# Rezoning Transportation Analysis

Petition Number: 2020-156

## Revision Log:

Date	Description
11-30-2020	First Review (KP)
01-21-2021	Second Review (KP)

**REZONING PLAN**

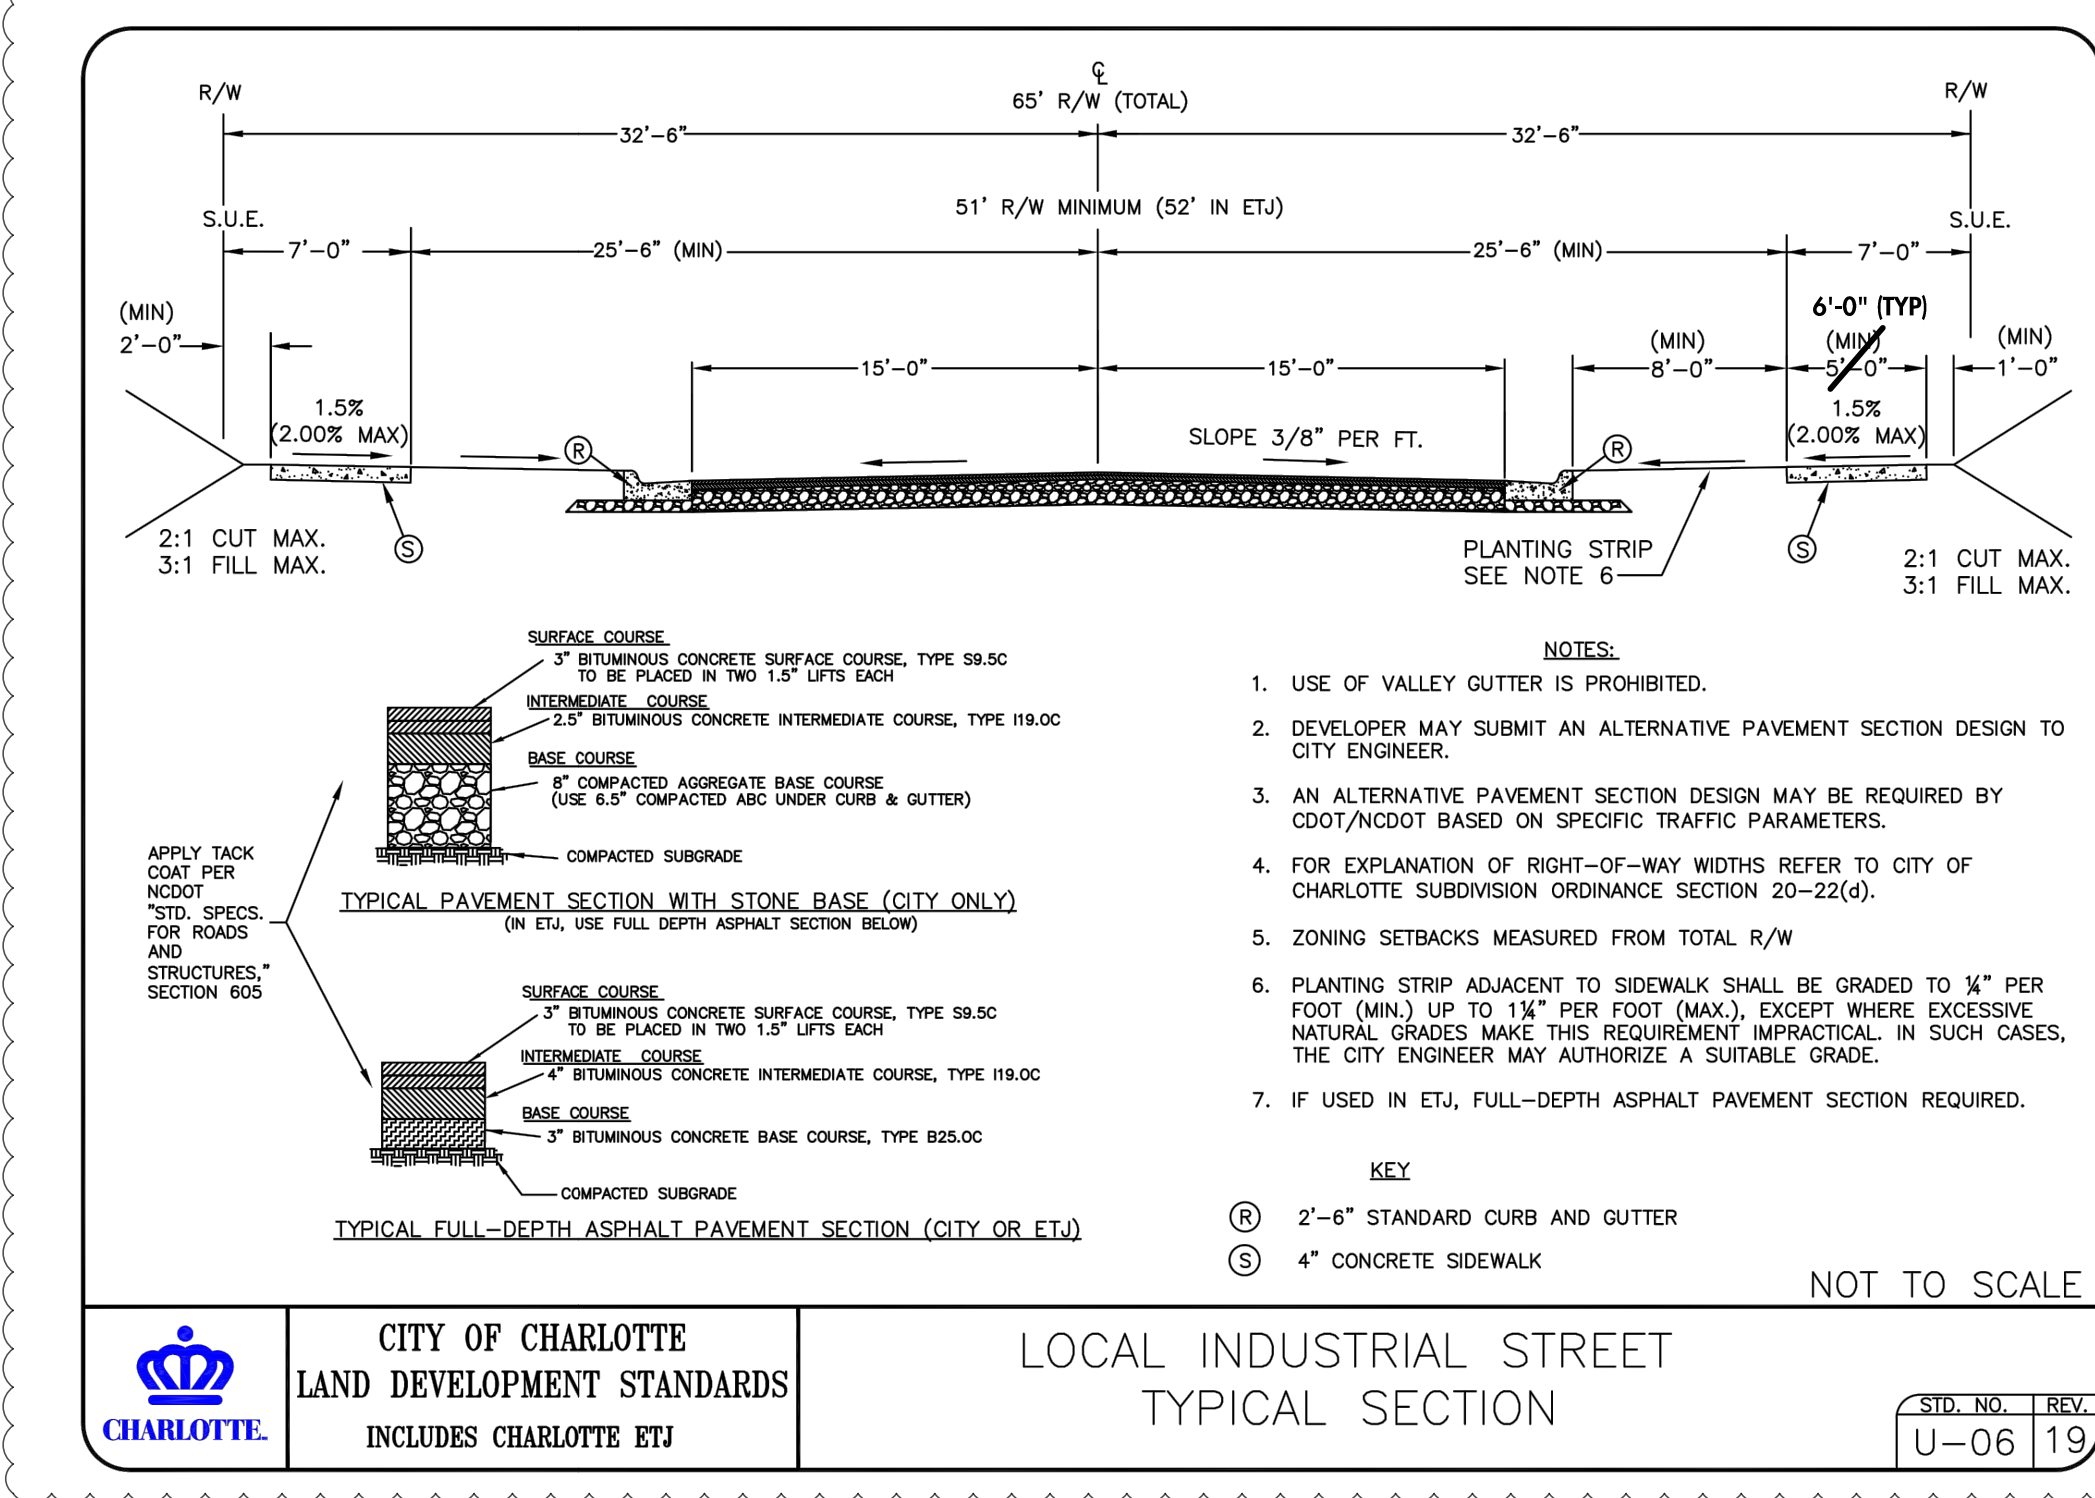
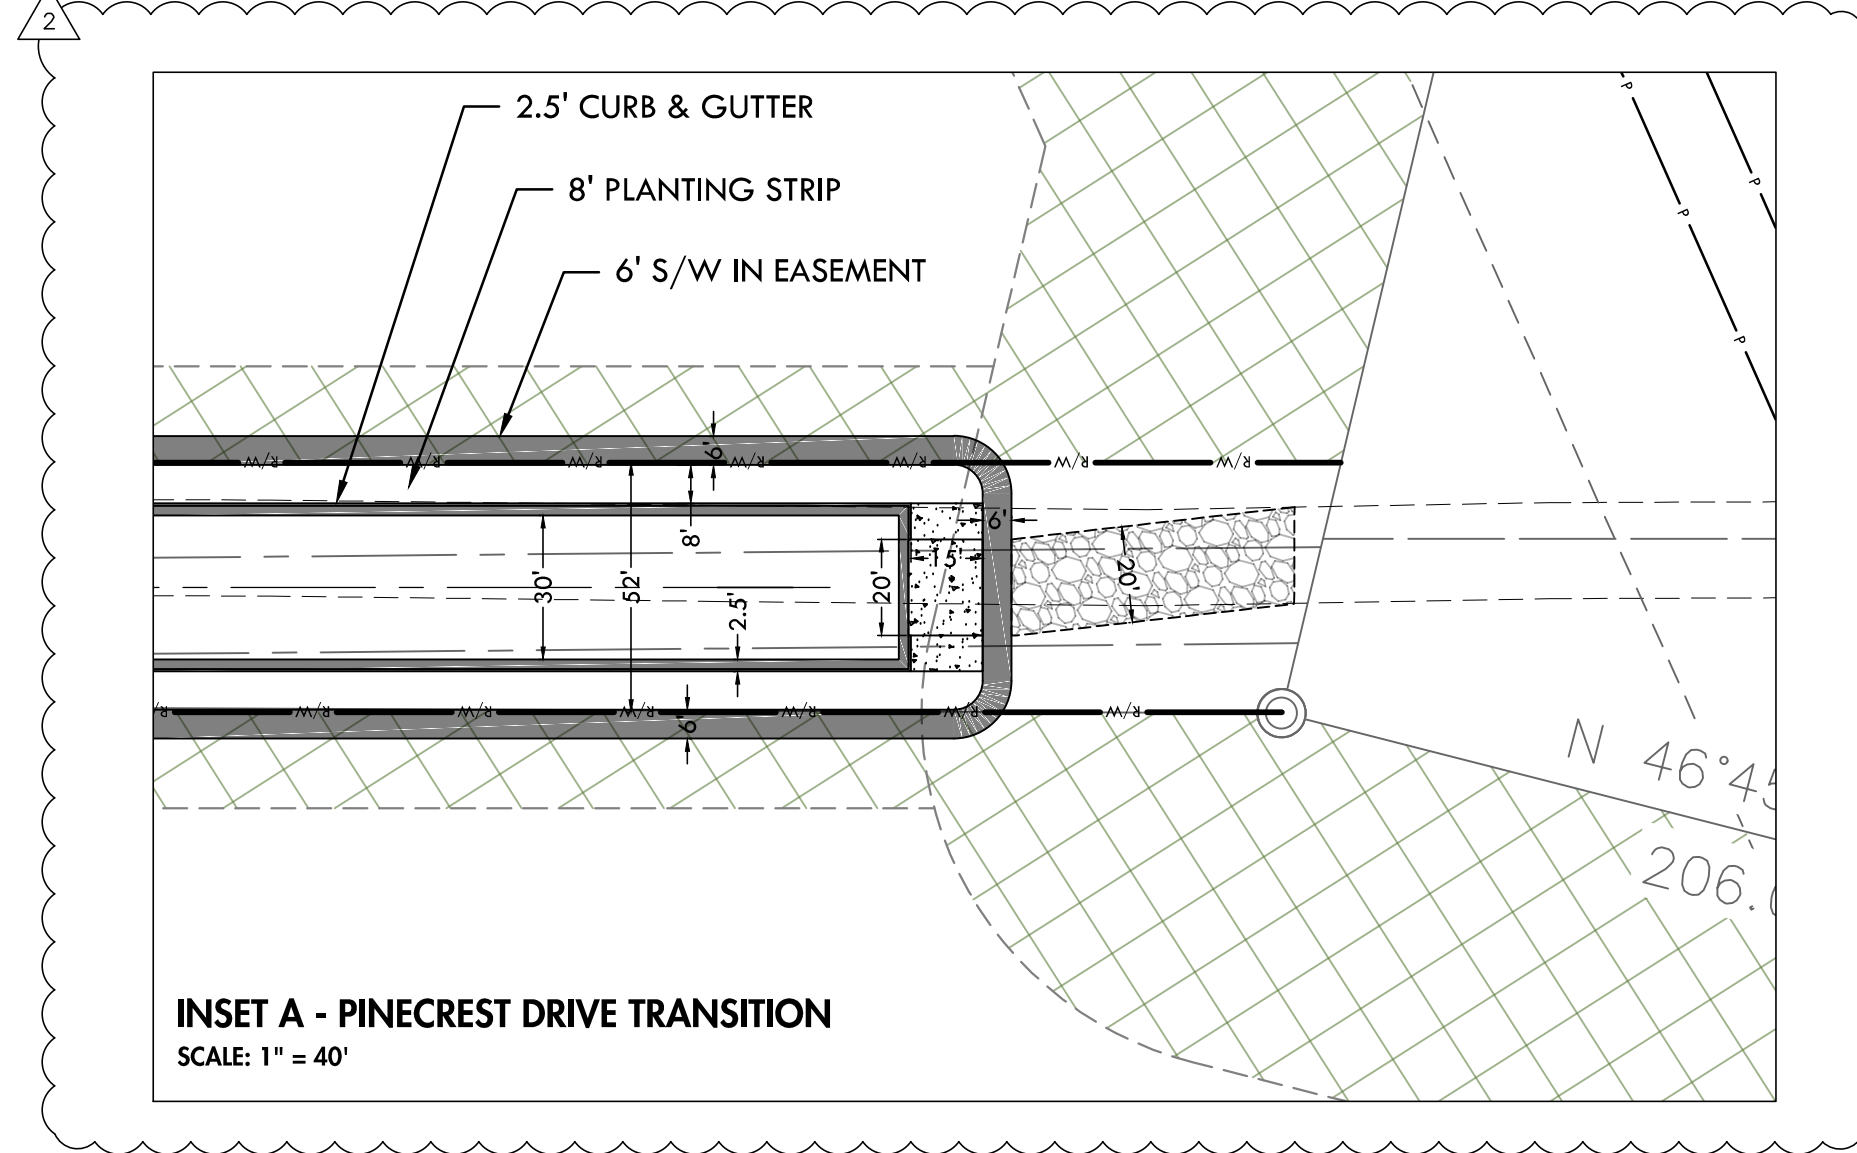
11. **New comment as a result of the 01-12-2021 resubmittal:** Revise the site plan by including a detail showing the roadway transition from the new public Local Industrial Street Cross Section, U-06, to the existing cross section of the privately owned Pinecrest Drive. Please include dimensions in this detail.

GAFFNEY PROPERTY
 REZONING PETITION NUMBER 2020-156
 CHARLOTTE, NORTH CAROLINA
 EASTGROUP PROPERTIES, INC.
REZONING PLAN

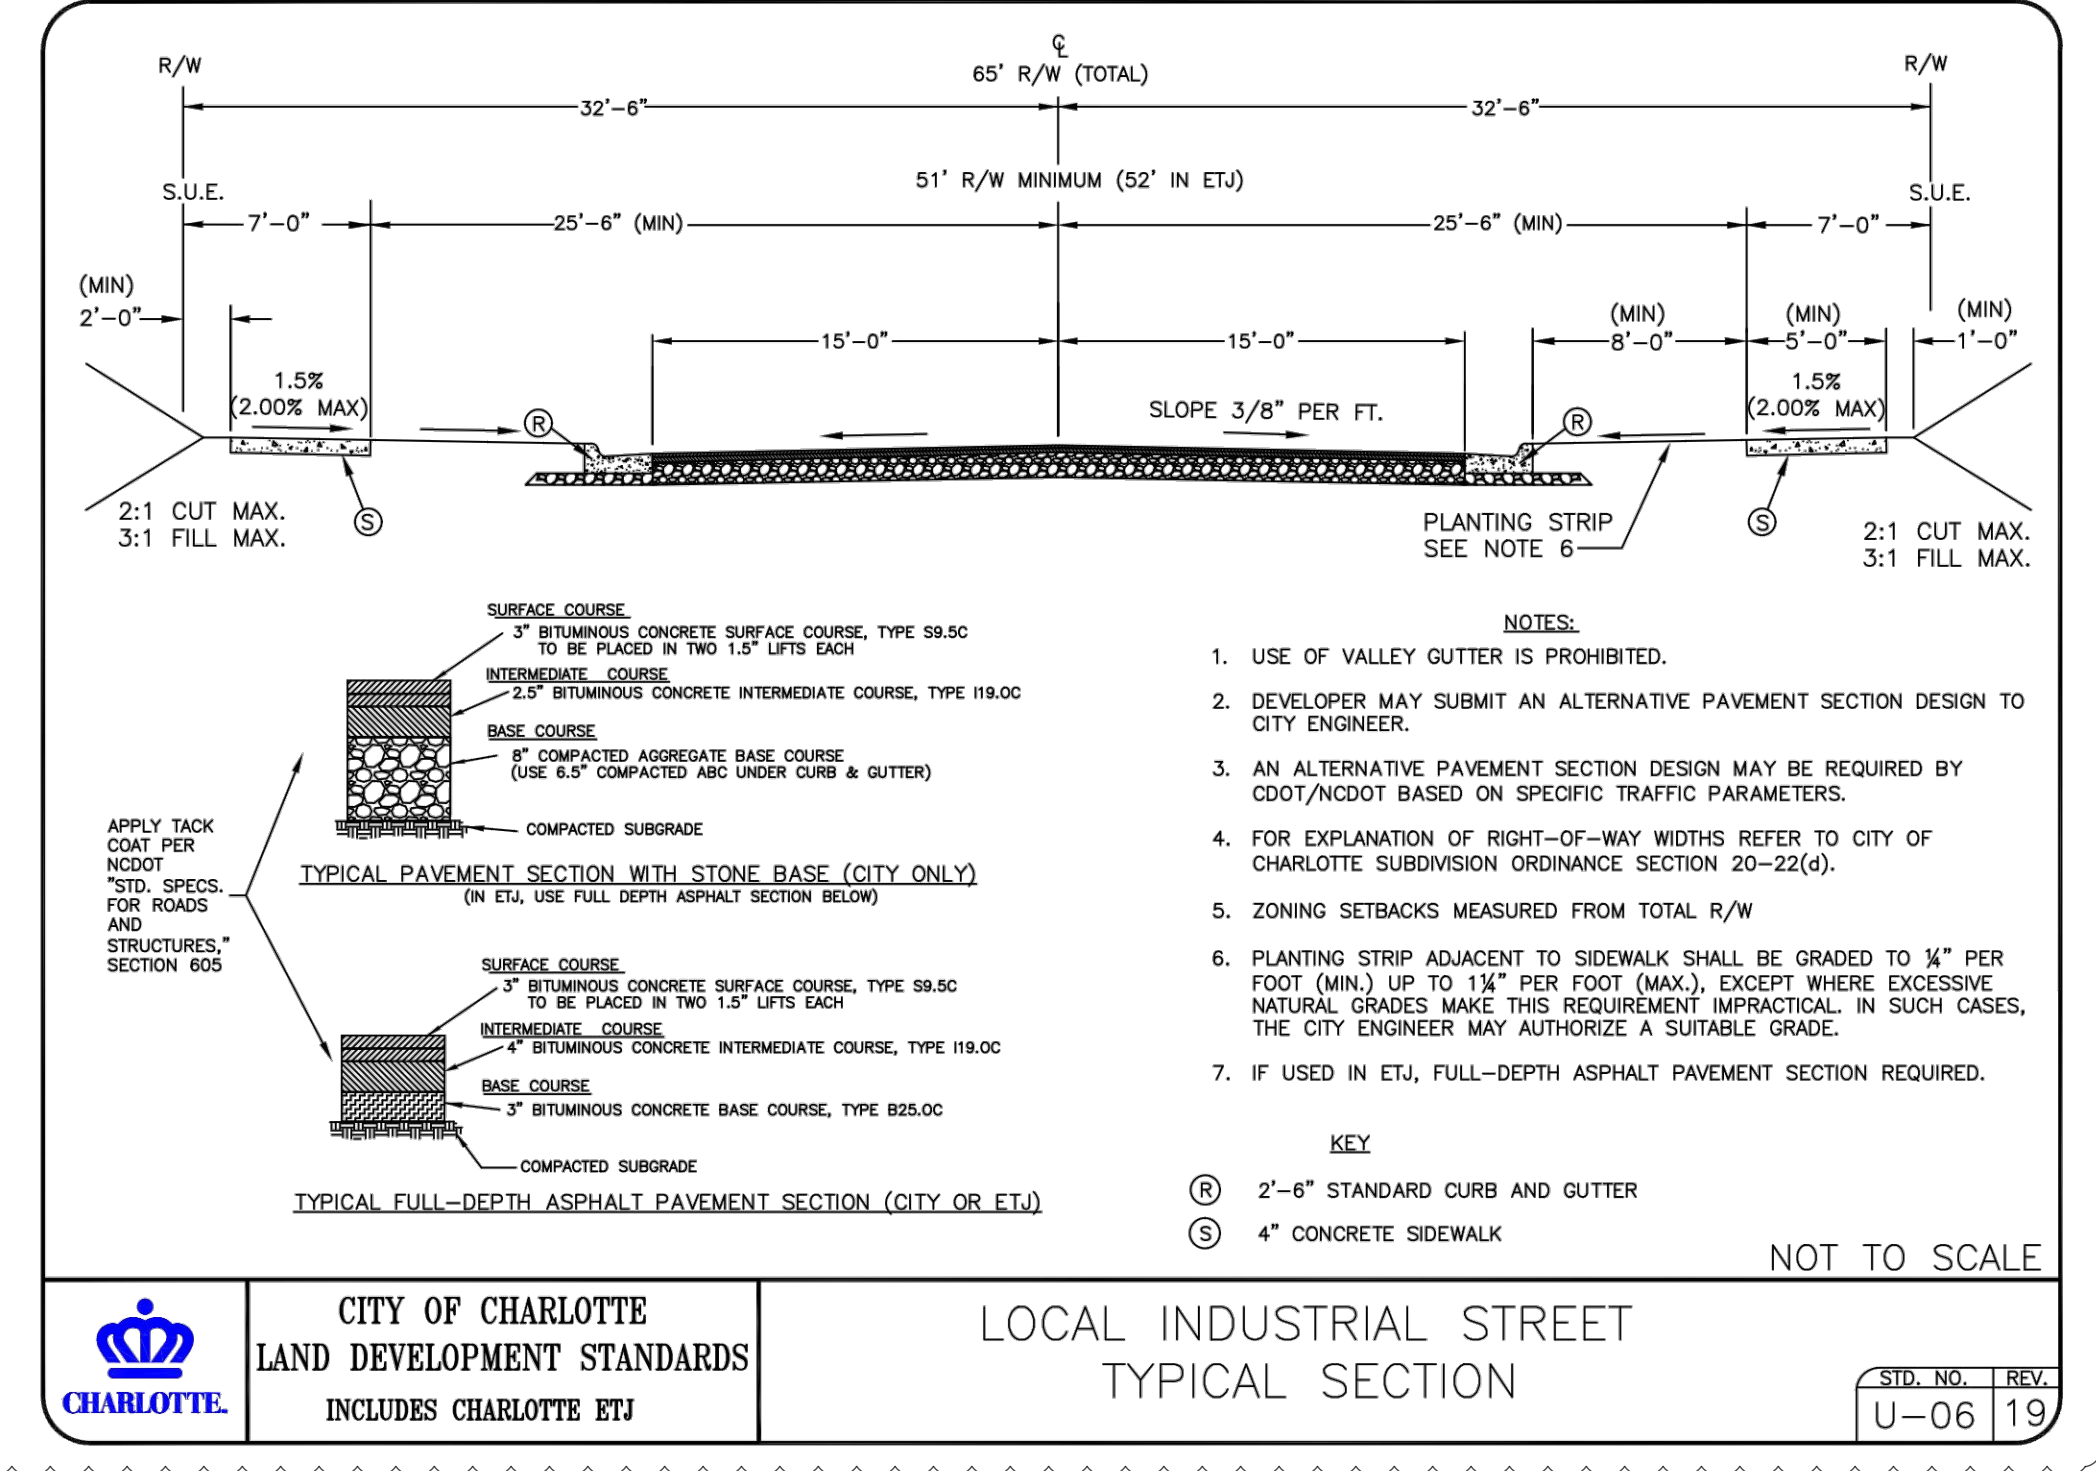
10. **New comment as a result of the 01-12-2021 resubmittal:** Revise the site plan and add a conditional note to coordinate with NCDOT, during permitting, to revise the median and/or turn lane striping, along the site's Shopton Road frontage, in accordance with NCDOT Standards.

12. **New comment as a result of the 01-12-2021 resubmittal:** Revise the site plan and conditional note 3.F to "Petitioner shall dedicate 85-feet of right-of-way, as generally depicted on the site plan, for the future Shopton Road Extension CTP Alignment."
